Our Case Number: ABP-319448-24

Re: Proposed Development of an 8 no turbine wind farm development and associated works on land within the townlands of Clonmellon, Kilrush Upper, Kilrush Lower, Newtown, Ballinlig, Carnybrogan, Cavestown and Rosmead, County Westmeath and Galboystown, Co. Meath.

I write with regard to the above development by Knockanarragh Wind Farm Limited for the development of an 8 no. turbine windfarm. Located at the townlands of Clonmellon, Kilrush Upper, Kilrush Lower, Newtown, Ballinlig, Carnybrogan, Cavestown and Rosmead, County Westmeath and Galboystown, Co. Meath.

Drawing Title
Turbine Elevation

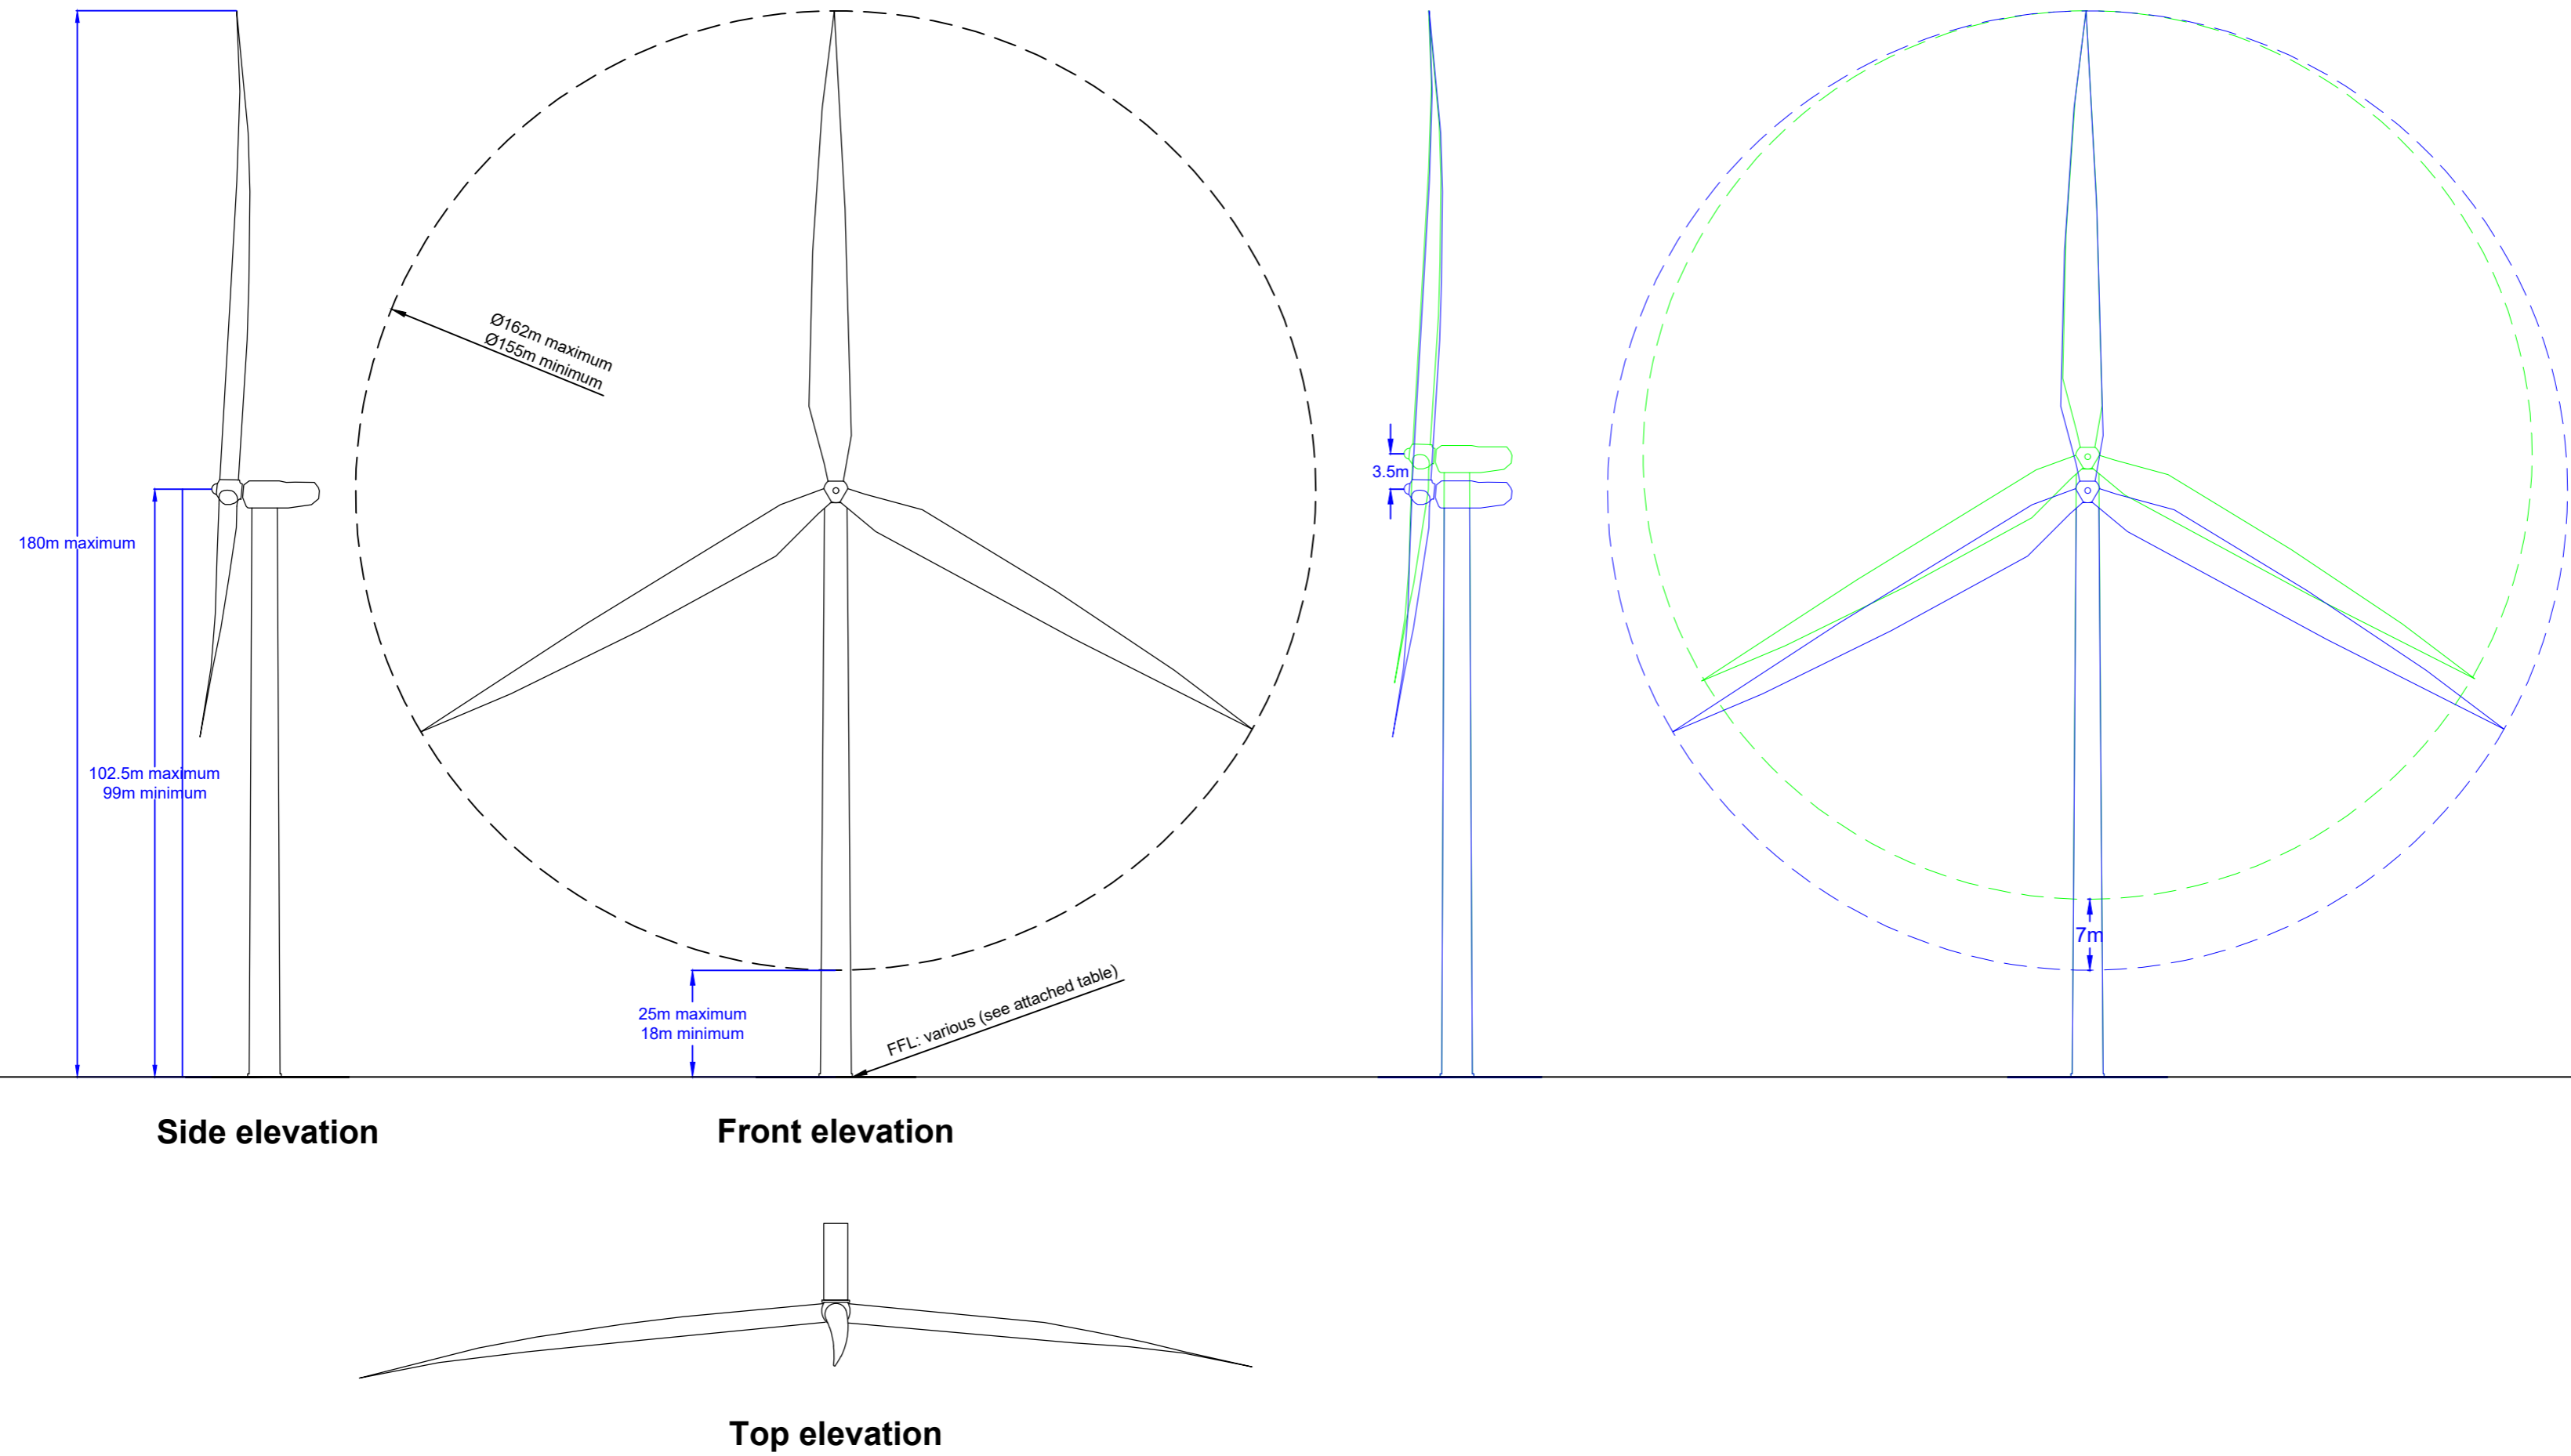
- All turbines should be illuminated by Type C, Medium intensity, Fixed Red obstacle lighting with a minimum output of 2,000 candela to be visible in all directions of azimuth and to be operational H24/7 days a week. Obstacle lighting should be incandescent or, if LED or other types are used, of a type visible to Night Vision equipment. Obstacle lighting used must emit light at the near Infra-Red (IR) range of the electromagnetic spectrum, specifically at or near 850 nanometres (nm) of wavelength. Light intensity to be of similar value to that emitted in the visible spectrum of light.
